## **Application by Net Zero Teesside Power Limited and Net Zero North Sea Storage Limited for the Net Zero Teesside Project**

### **The Examining Authority's written questions and requests for information (ExQ1)**

**Issued on 19 May 2022.**

PLAN VIEW
Scale 1:5000

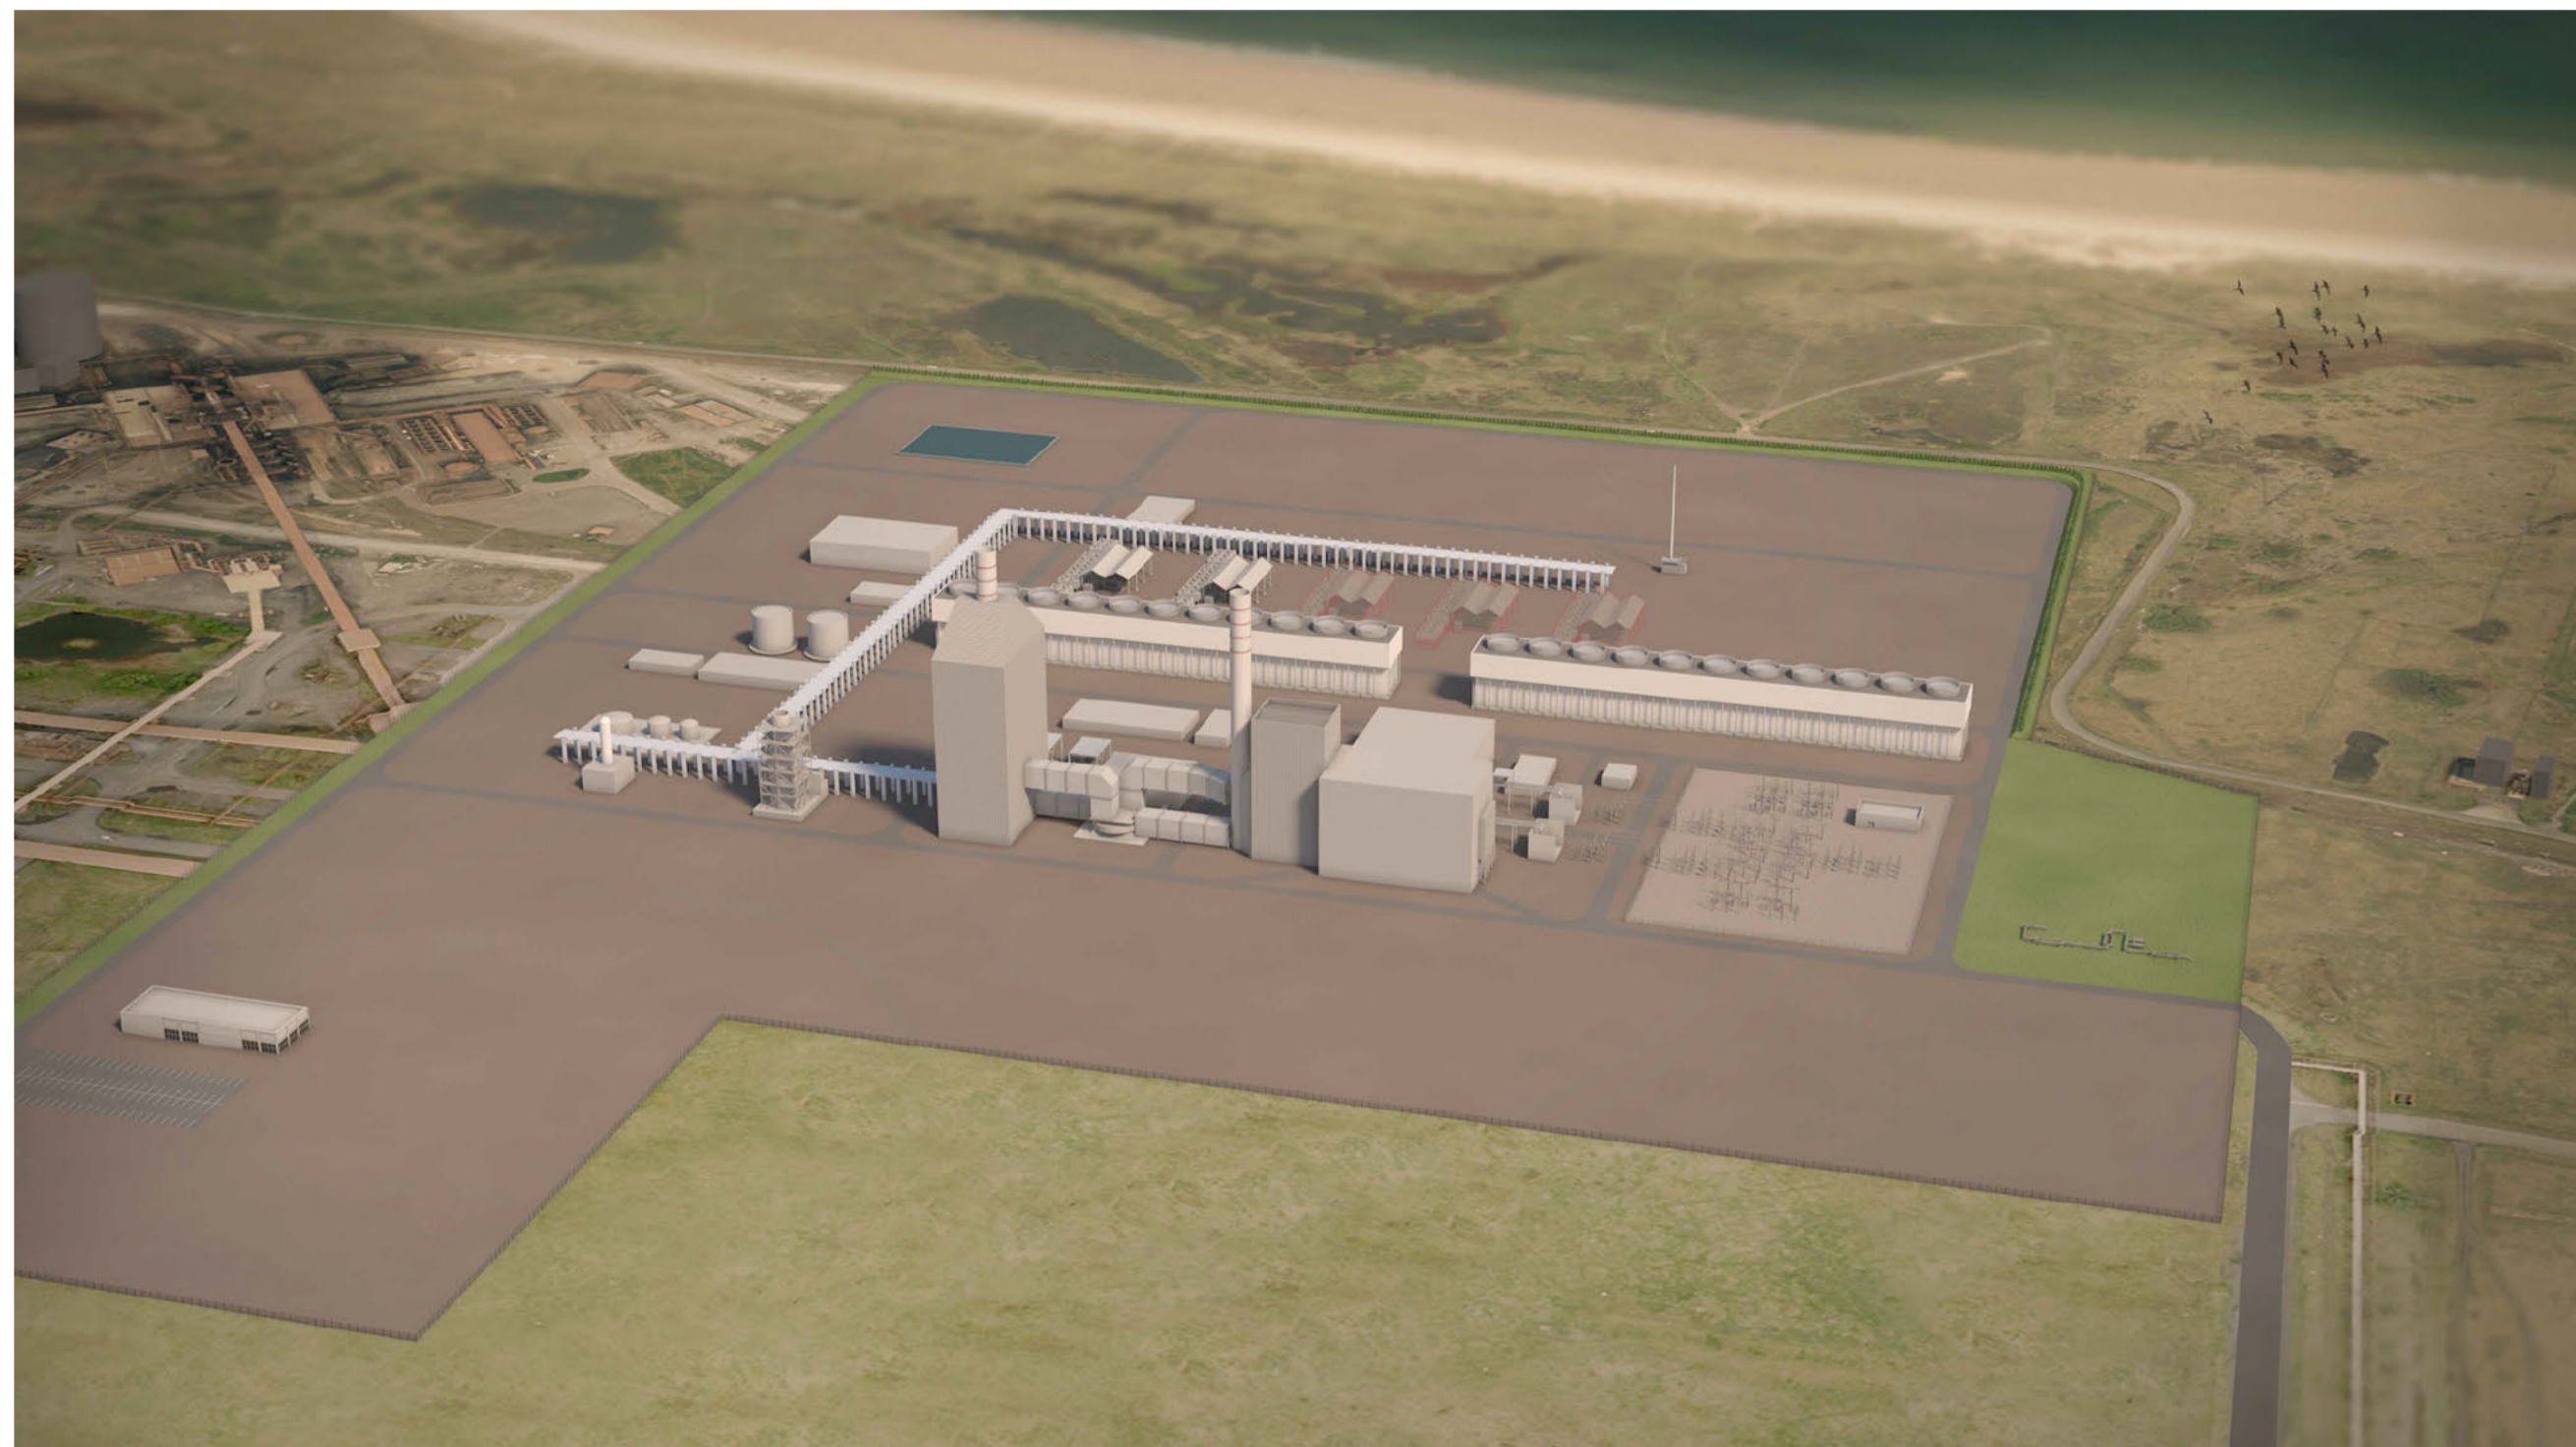
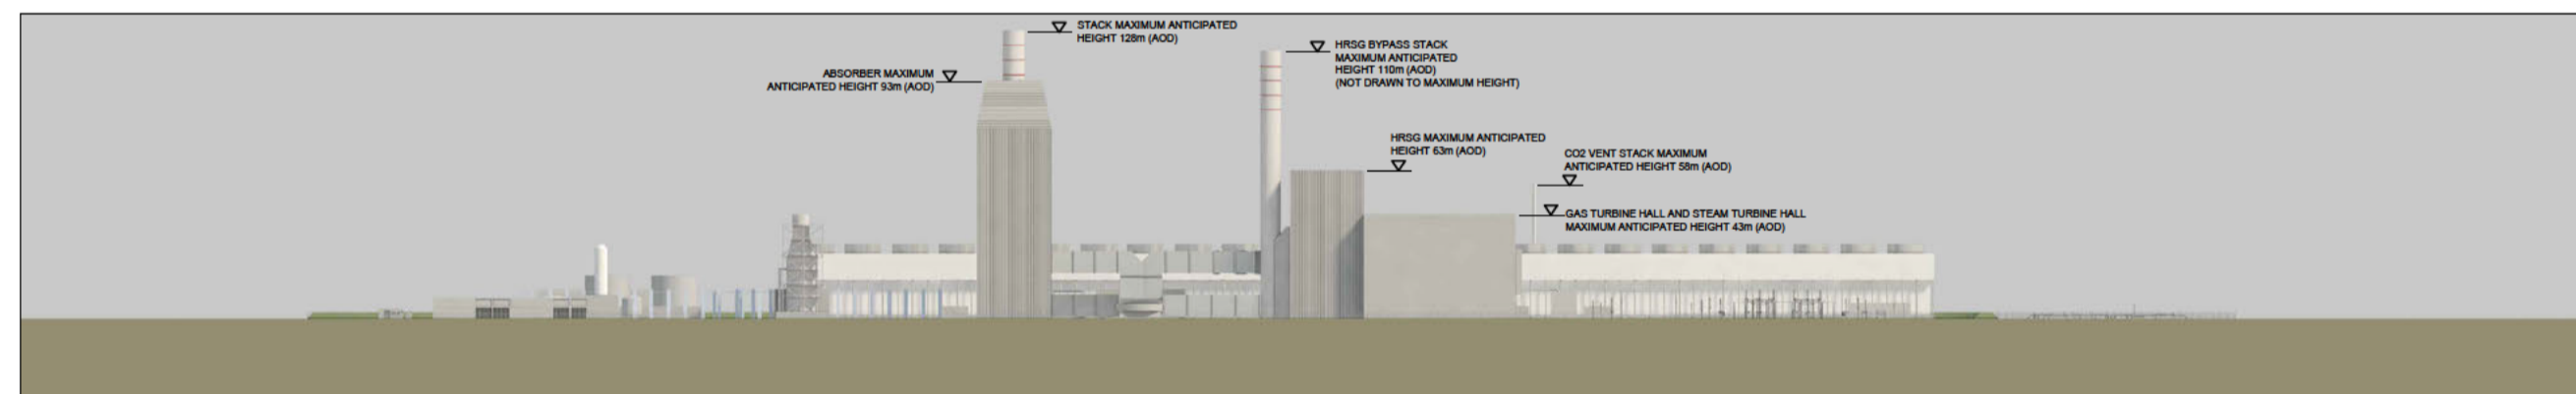
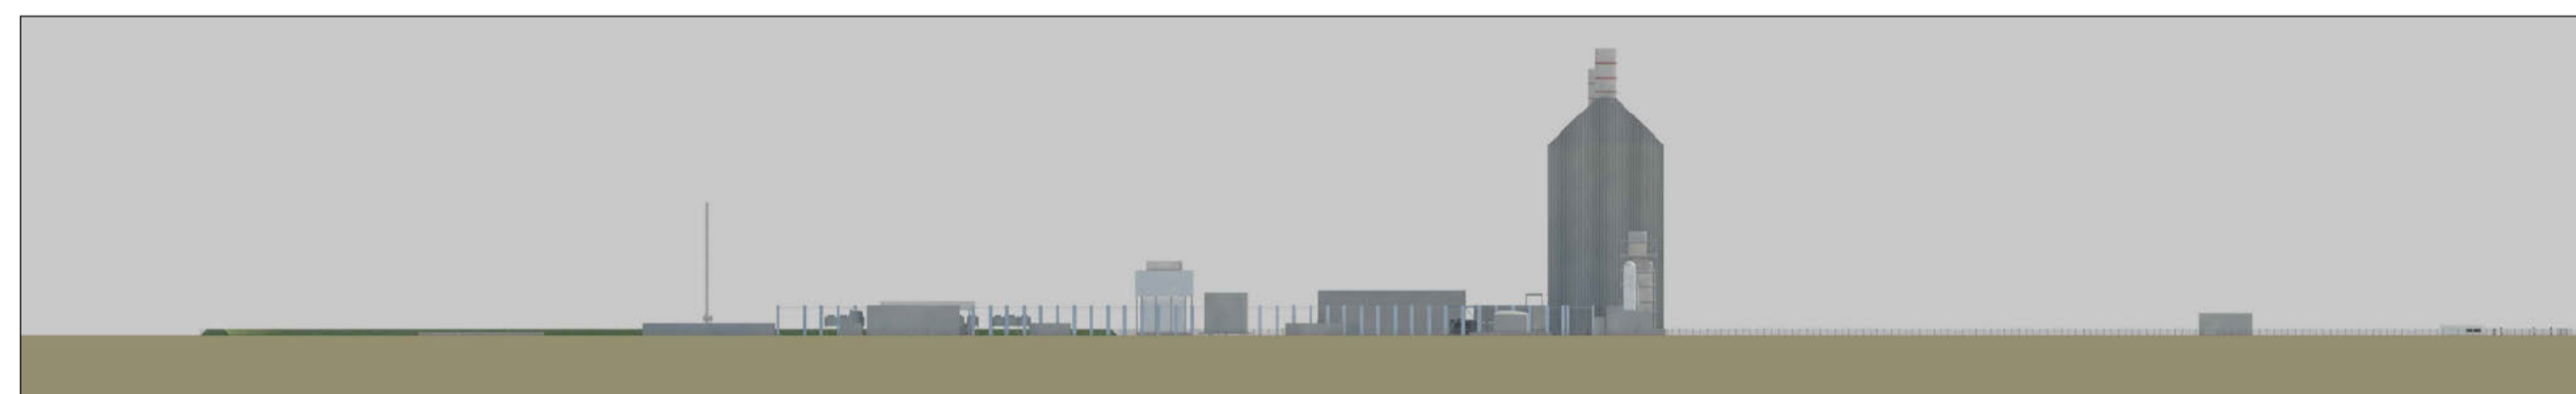
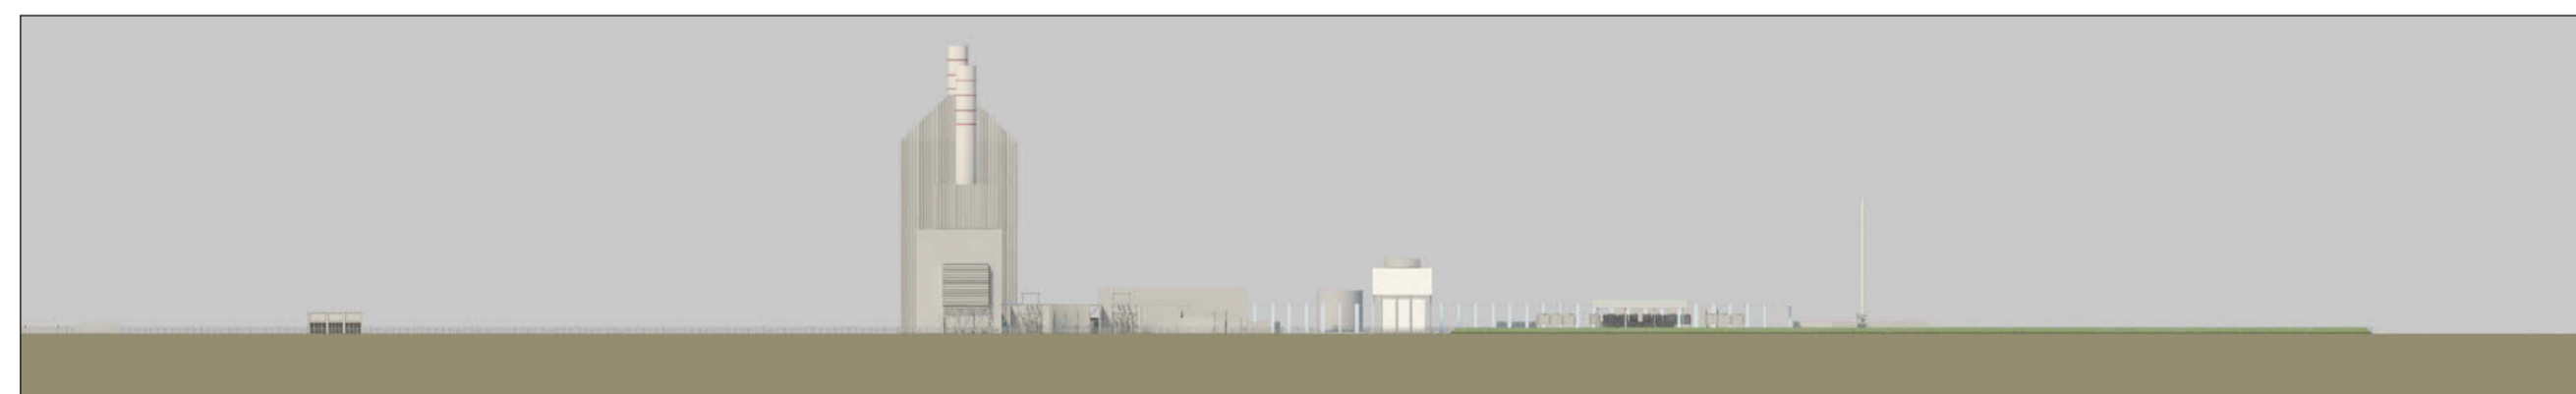
ExQ1	Question to:	Question:
		[RR-012] and National Grid Gas PLC [RR-013].
GEN.1.6	Applicants	<p>No maximum height for the heat recovery steam generator (HRSG) stack is specified in Environmental Statement (ES) Chapter 4, Table 4-1. An anticipated maximum height of 110m Above Ordnance Datum (AOD) is annotated on the Power Capture and Compression (PCC) Site Elevation Plan but this is not identified as a document to be certified in Schedule 14 of the dDCO. No parameters are stated in ES Chapter 14. The EA [RR-024] stated that the Applicant should provide a worst-case prediction of the height, width and location of the HRSG stack with regard to the air quality assessment. Minimum and maximum parameters of the stack for the auxiliary boiler (if required) have not been stated and the stack is not annotated on the PCC Site Elevation Plan. No maximum width is stated for either stack. Their final locations are not fixed but are shown indicatively on ES Figure 4-1 and siting would be restricted to development areas shown for Work No. 1A and 1C on the Works' Plans.</p> <p>Can the Applicants confirm the minimum and maximum parameters (height and width) that have been used in the ES assessments for the heat recovery steam generator stack and auxiliary boiler stack?</p>
